Your Ref: OWPC22319
Our Ref: BR/63/19/PL 21-02-2019
Please ask for:
Stuart Corbey

Demolition of existing building and erection of 6No. three bedroom dwellings with associated accesses and car parking.

15-17 Kew Gardens Bognor Regis

Thank you for your internet representation made on 24th April 2019 which has been recorded as '**an objection**' with the comments as follows:

STREET SCENE FACING KEW GARDENS
(1:100)

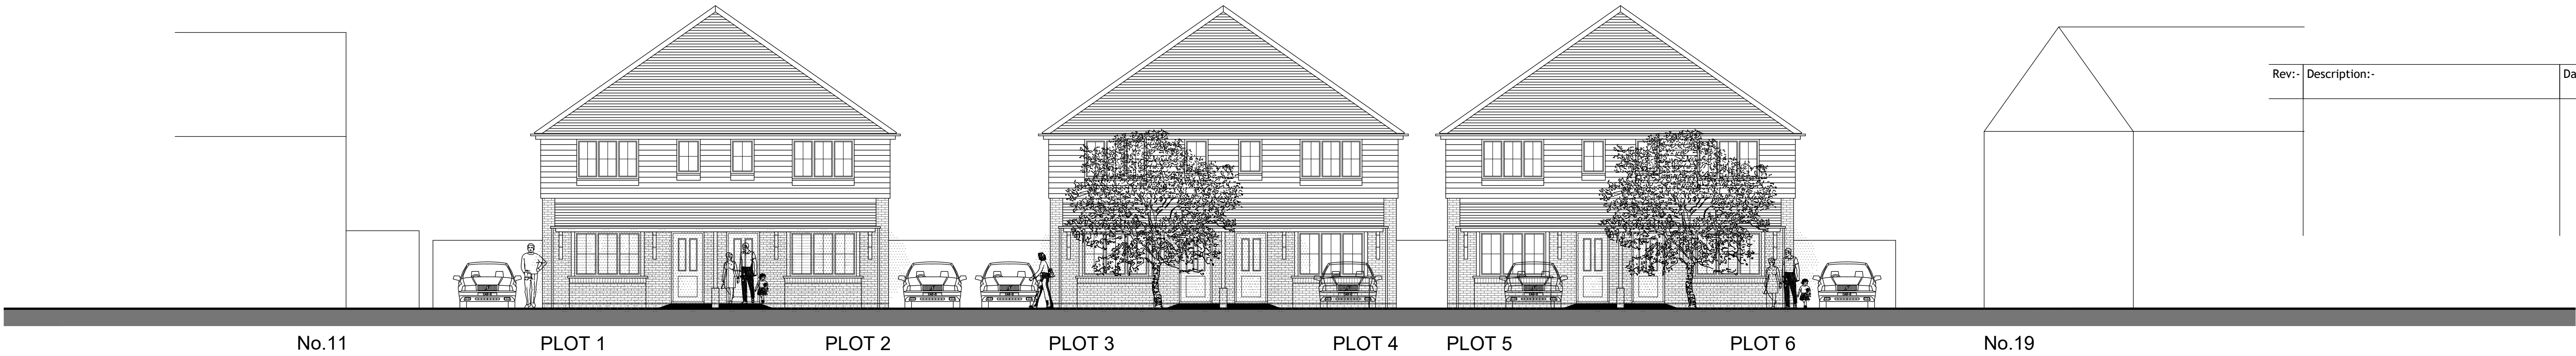
I cannot understand why this proposed plot 5&6 has been set so far back as to where is will be overshadowing our garden. Although the developers may say they are looking to 'replicate' what is already in Kew Gardens this has not been followed as all driveways currently in Kew Gardens are between plots, this developer has pushed the driveways IN FRONT of their proposed plots in order to try and squeeze 6 properties onto the land rather than 4 which is what should be in keeping and replicate what is already in Kew Gardens. A sub-sequence of this is the houses especially plot 5&6 have been pushed back to now end up in line with our garden rather than the actual property.

BLOCK PLAN (1:500)

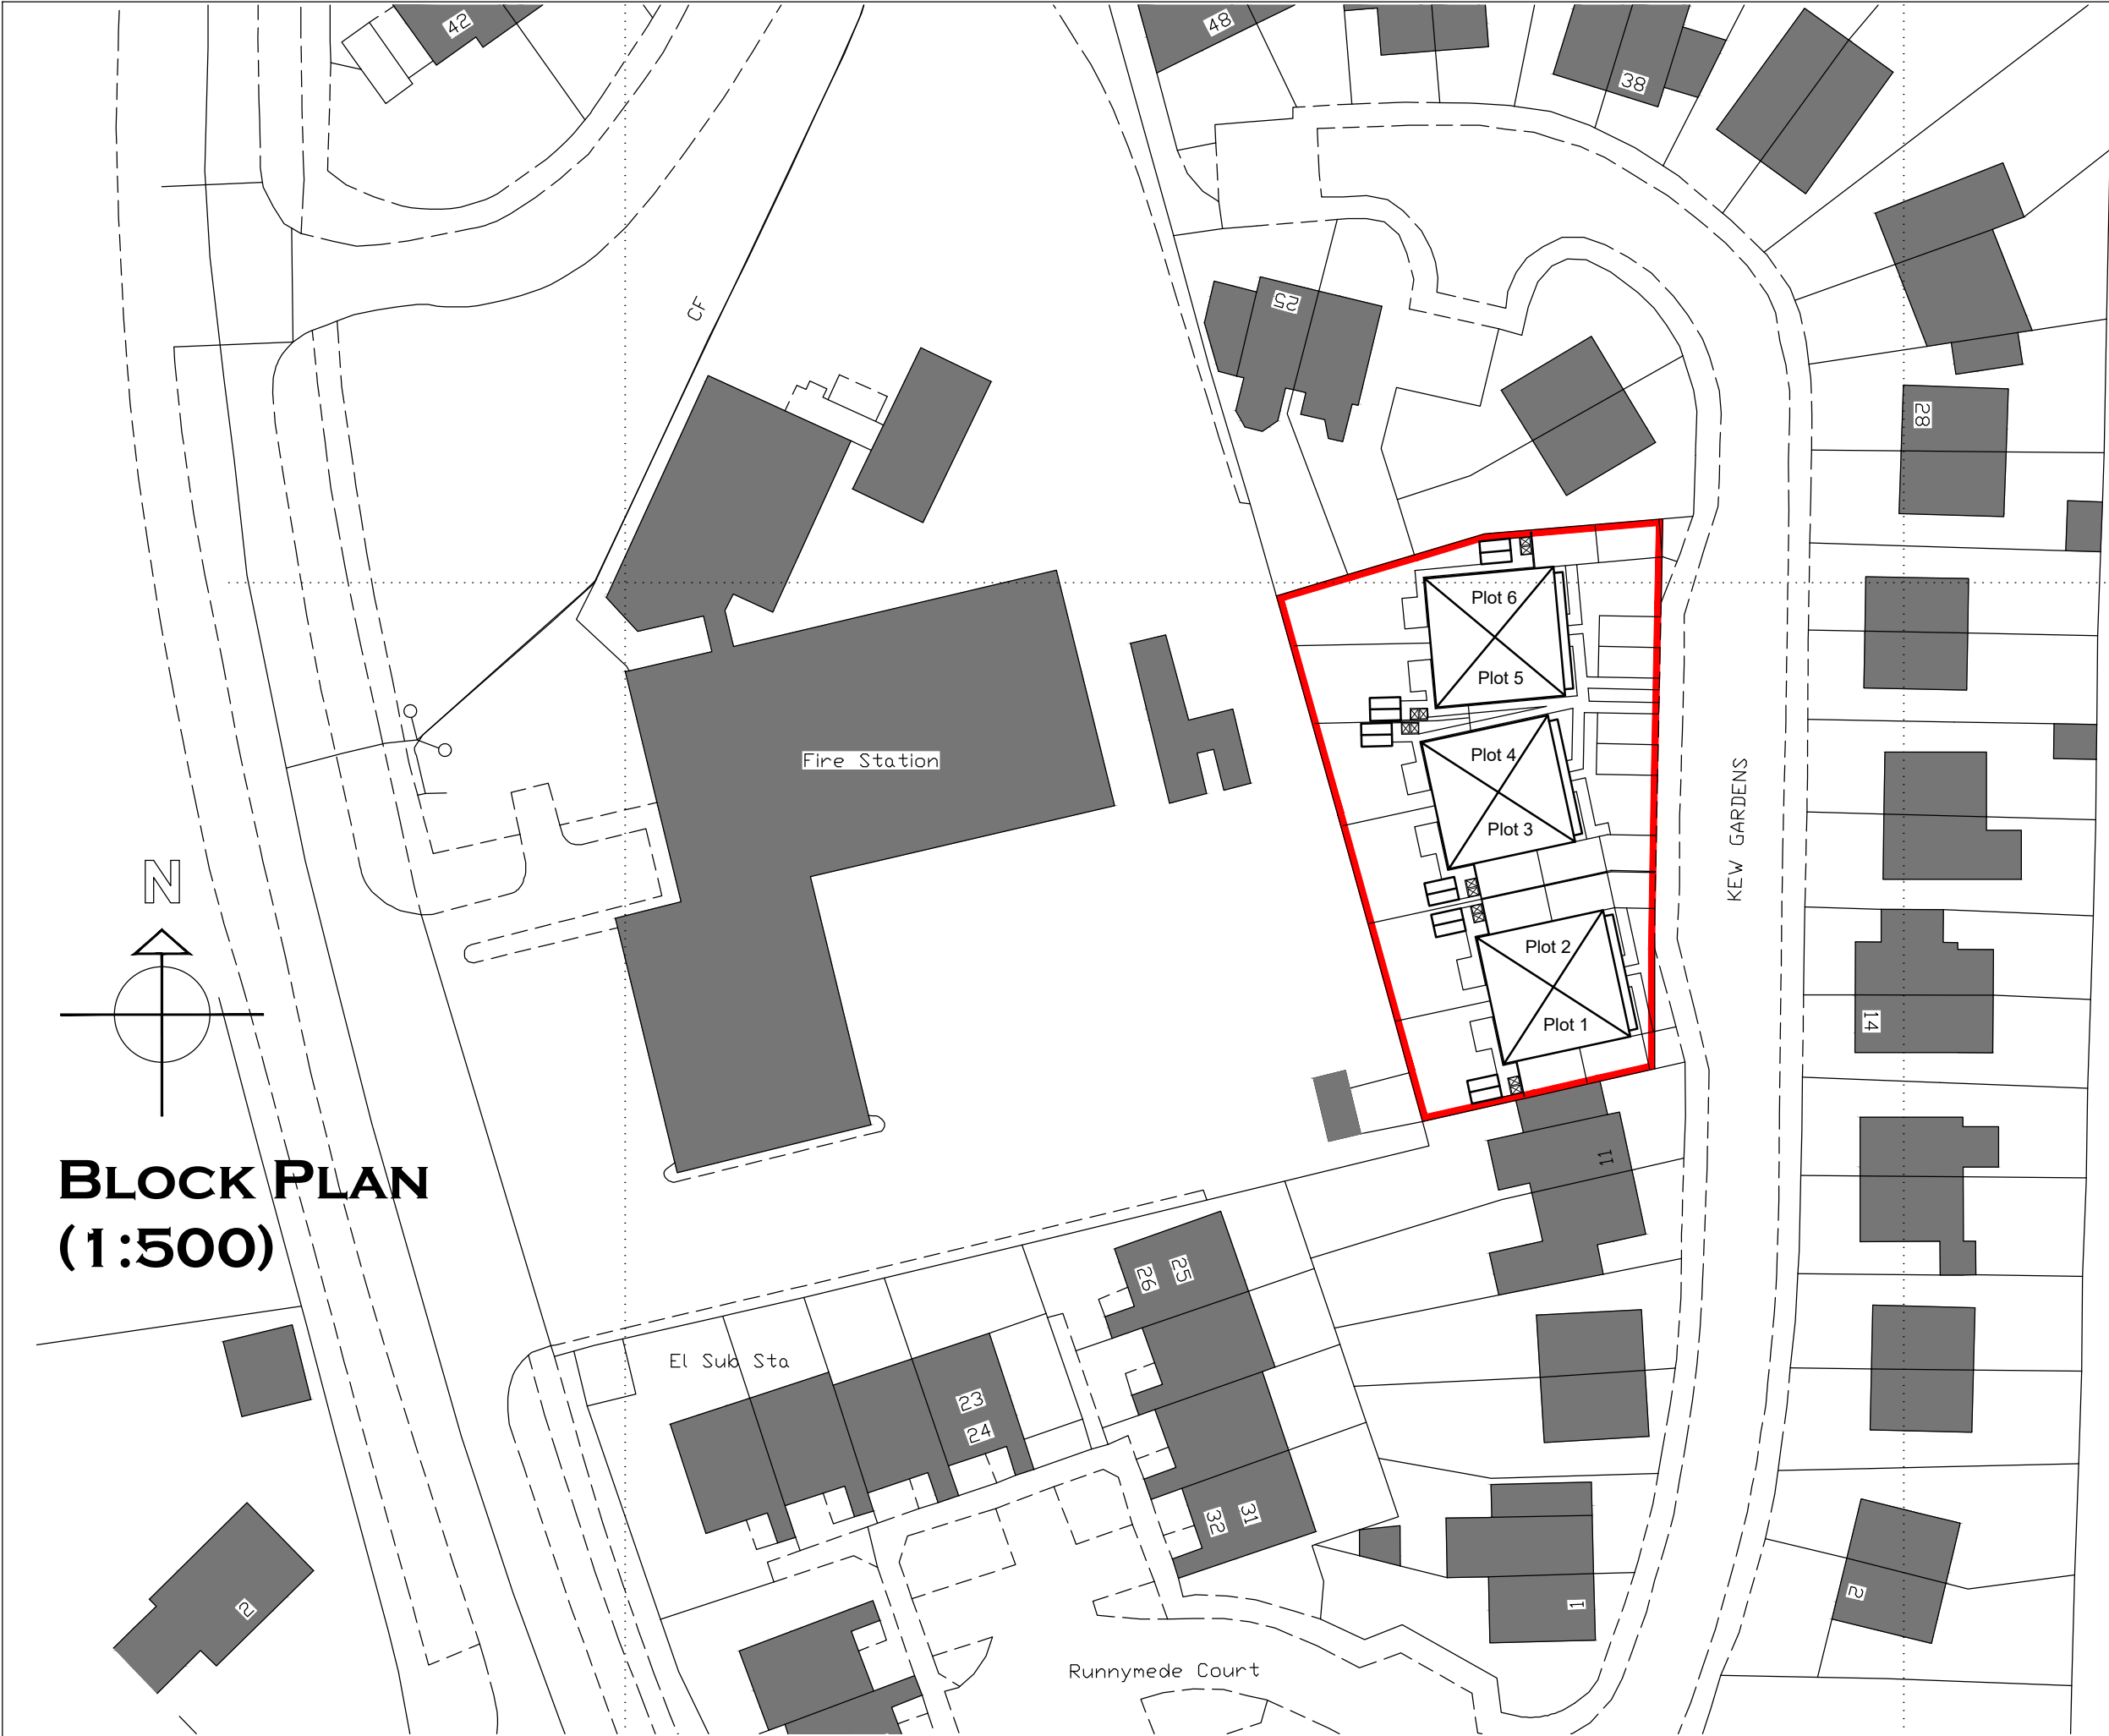
Firstly my major objection to this proposed development and main concern is the fact that plot 5&6 (and also plot 3&4) have been situated in such a way that they have been so heavily set back away from the road, which means that plot 5&6 which is a large semi-detached plot of 2 x 3 bedroom properties will be a matter of feet away from our garden and will a) mean that our garden will now consist purely of a huge brick wall on the south facing side of our garden and b) blocking almost the whole days sunlight into our garden, patio and rear of our house.

I have concerns for the road as a whole, one of the main reasons being that why is the lay-by being removed? This is essential to help out cul-de-sac operate as its used throughout the day and night not only for visitors, but for tradesmen, carers and others. Also this keeps cars from parking on pavements which stops access for push chairs and wheelchairs - But the main concern is if the lay by is removed and we then enter a situation where cars are parking on pavements and partially blocking the road what then happens if emergency services need to attend the end of the road and we have cars blocking the way?
